## Portishead Branch Line (MetroWest Phase 1)

8.6 – Letter from Colin Medus, North Somerset Council re: Offsite planting on the A369 Portbury Hundred dated 12 September 2019

**The Proposed Portishead Branch Line (MetroWest Phase 1) Order  
Offsite planting on the A369 Portbury Hundred**

2.57 - Portbury Hundred Location of Additional Tree Planting

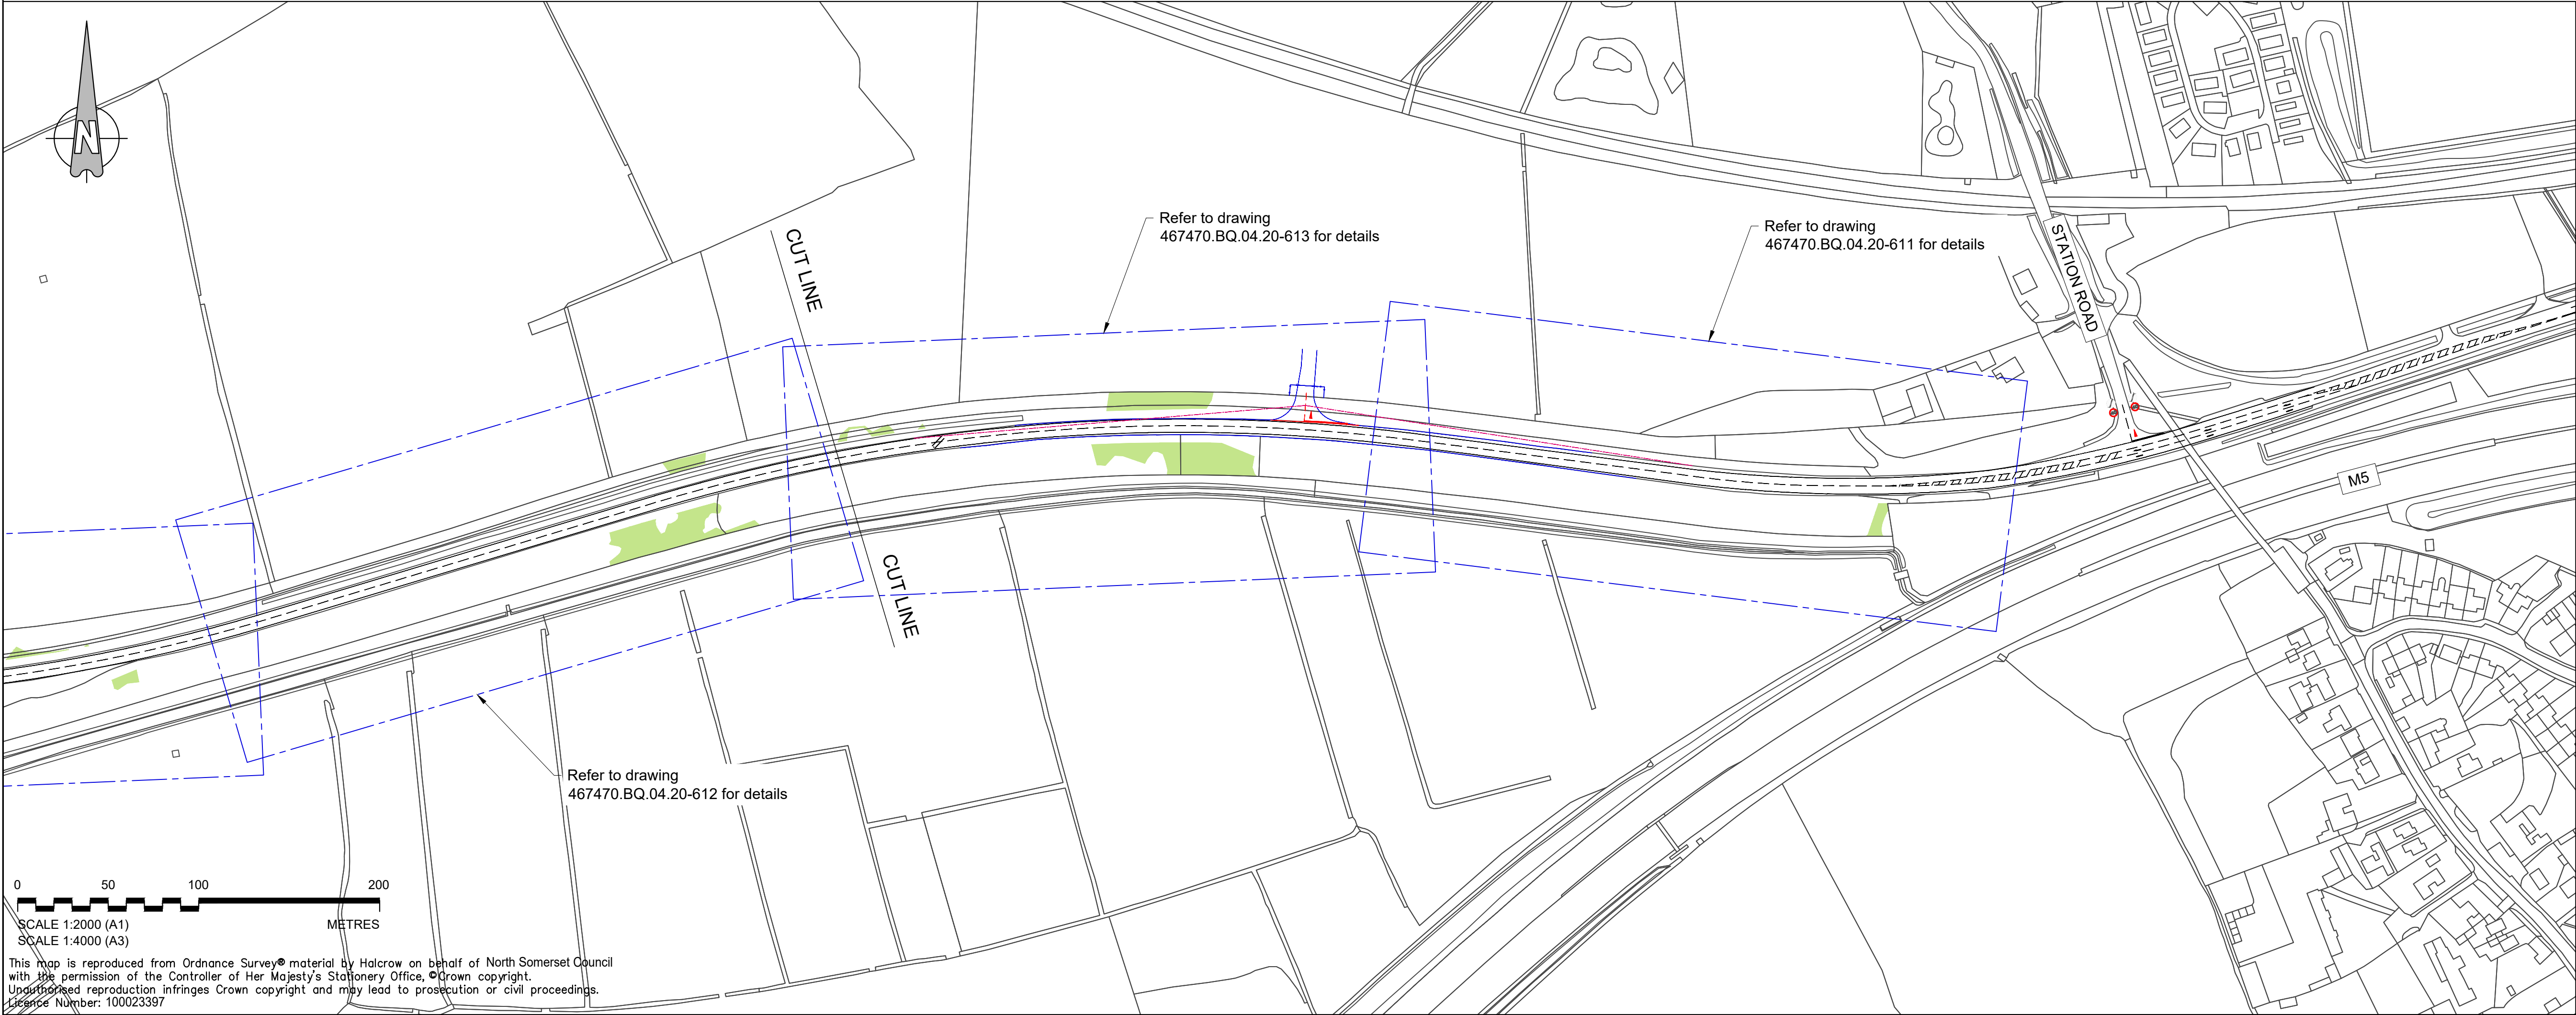
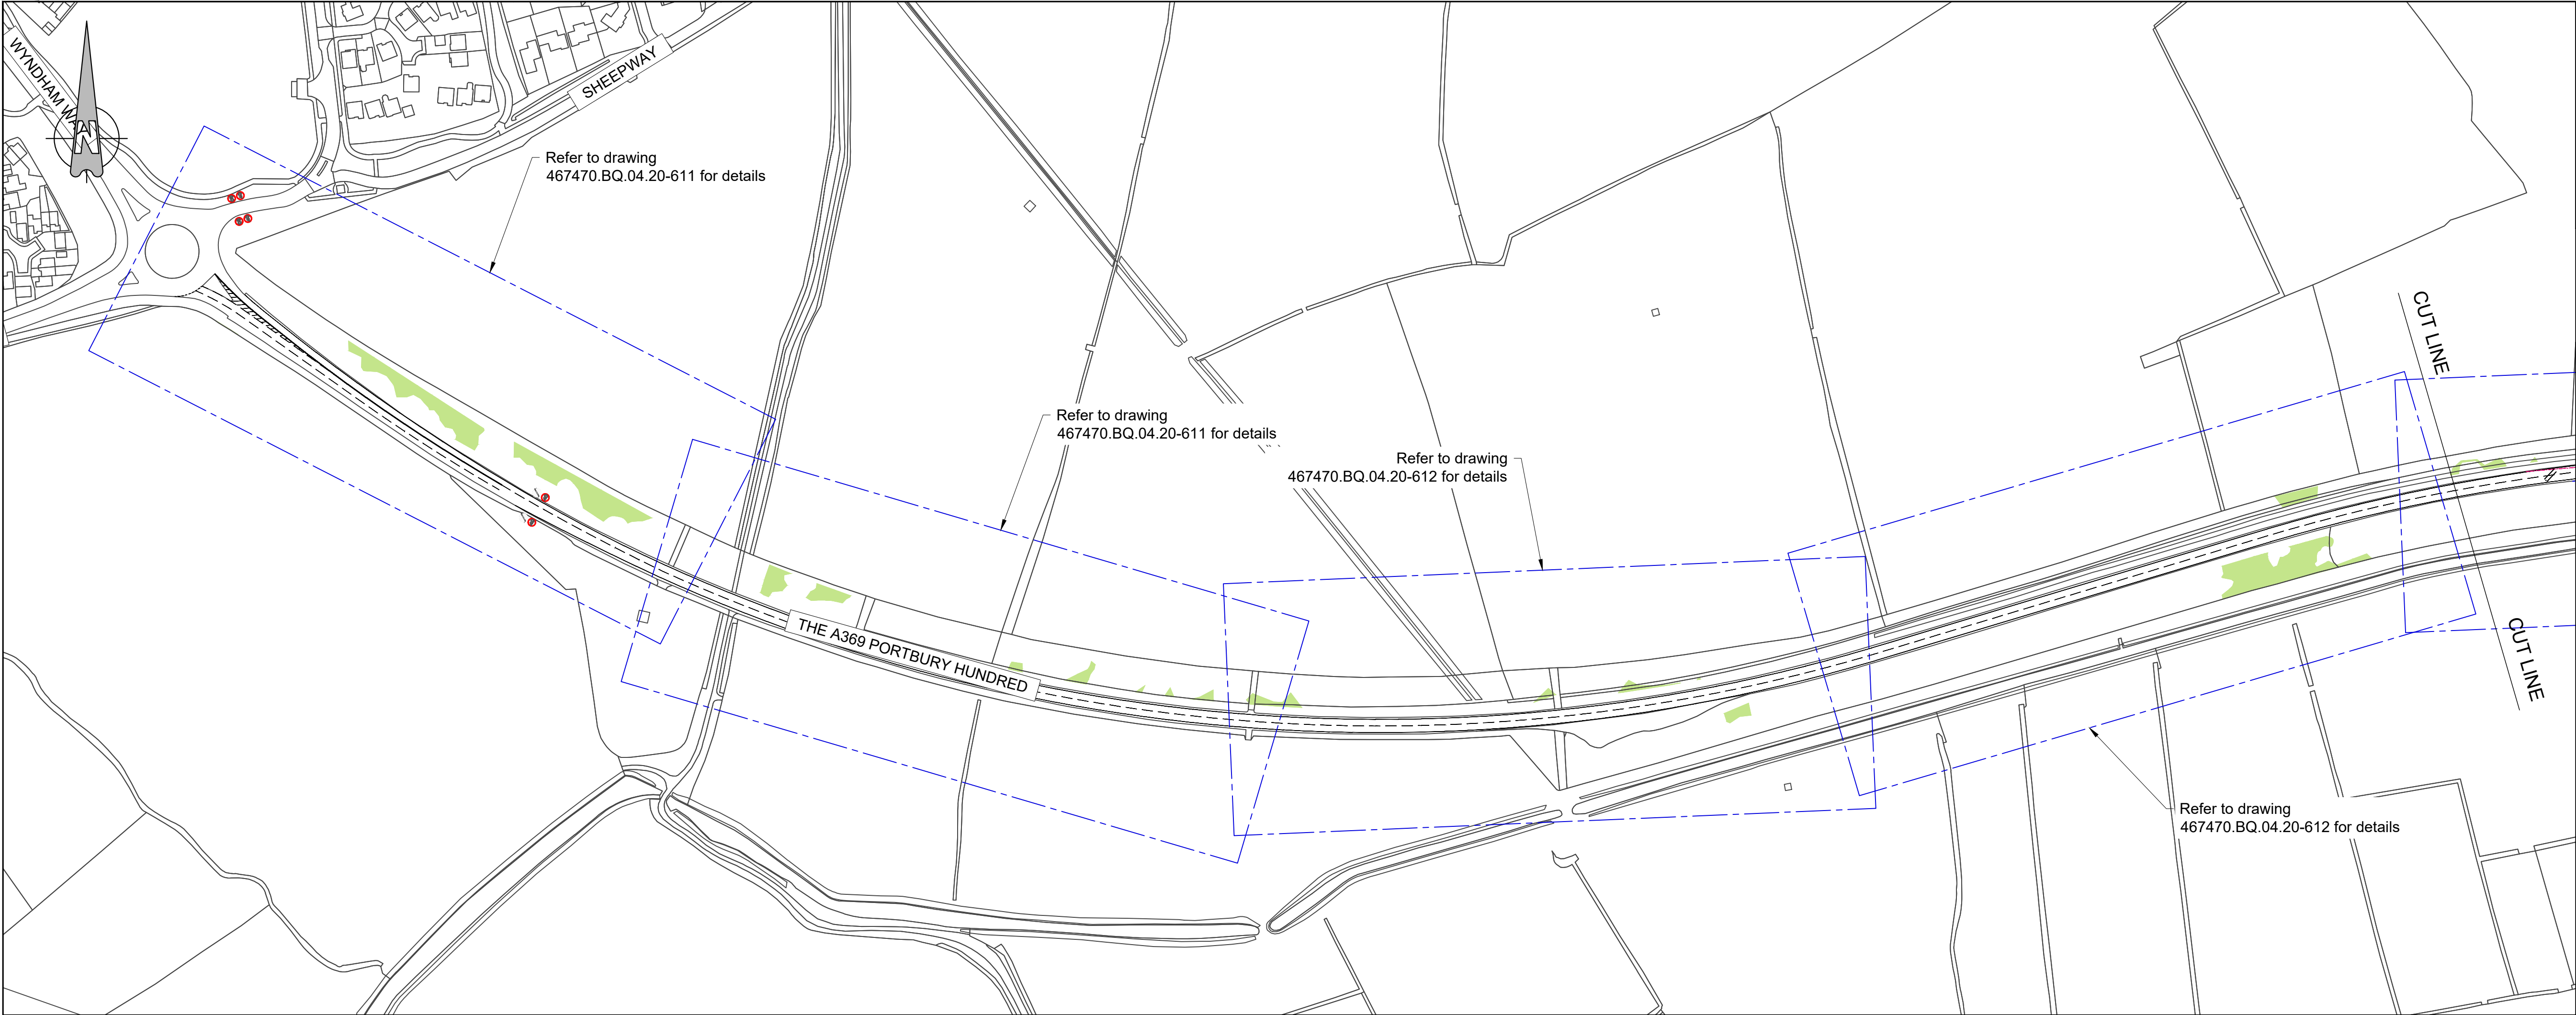
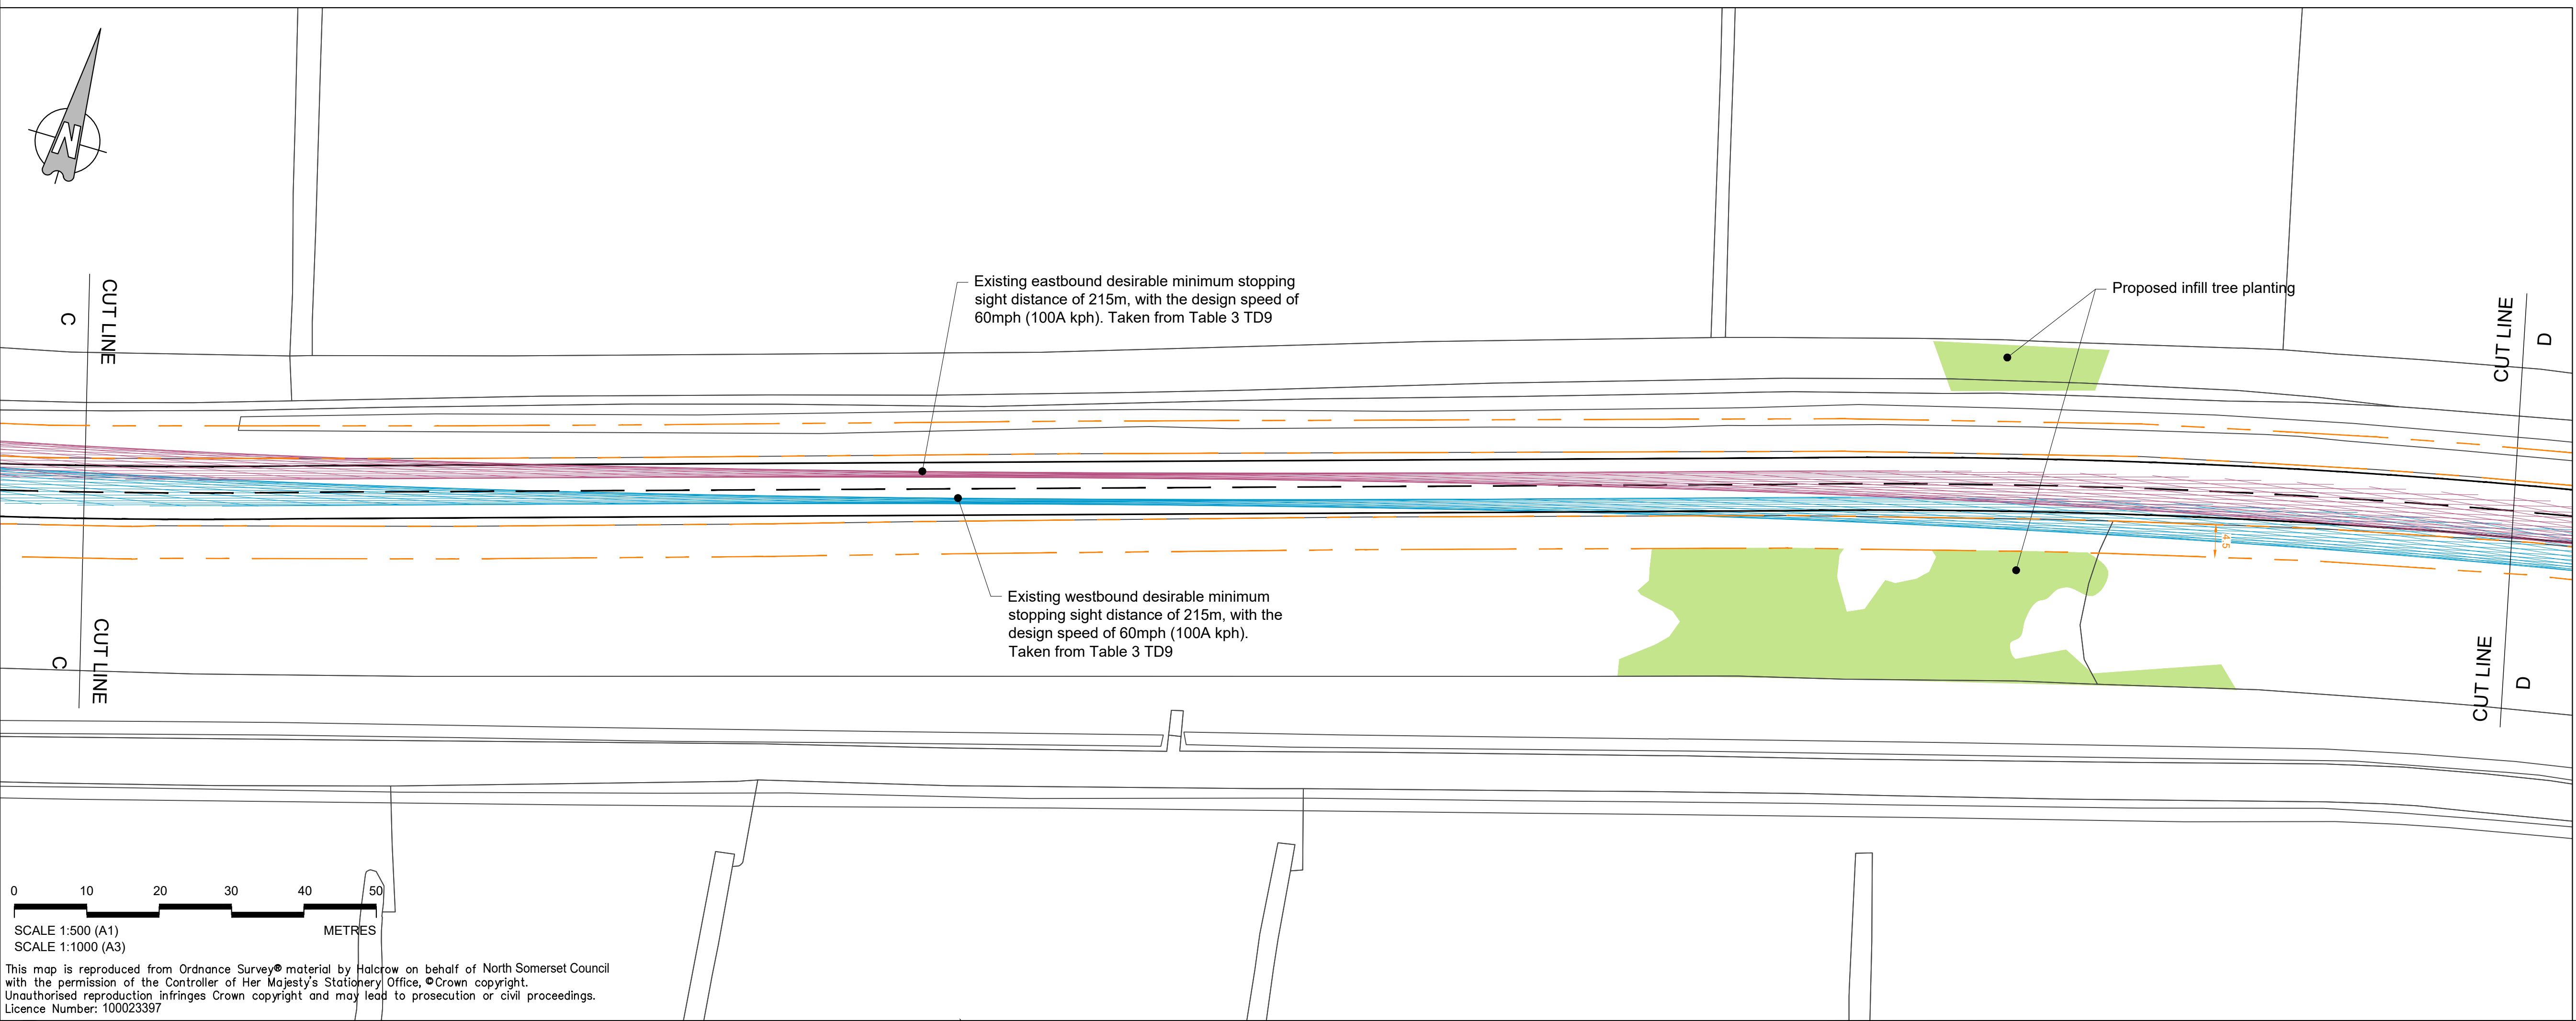
I understand this proposed planting (which is shown on plans 467470.BQ.04.20-610 to 613 enclosed with this letter) is required to provide an alternative bat commuting corridor in addition to that currently provided by the disused railway.

I can confirm that all of the proposed planting shown on the plans referred to above is within the public highway and the sum of tree planting totals 0.52 hectares. The following tree species would not be acceptable; willow and poplar. The types of tree species we would accept are field maple, hawthorn and hornbeam. A tree planting list can be agreed at the detailed design stage.

I can also confirm that North Somerset Council as local highway authority is content to, at the relevant time, grant licence to the MetroWest project and its contractors to provide the proposed planting in accordance with the plans referred to above, subject to agreement at the detailed design stage on the planting list.
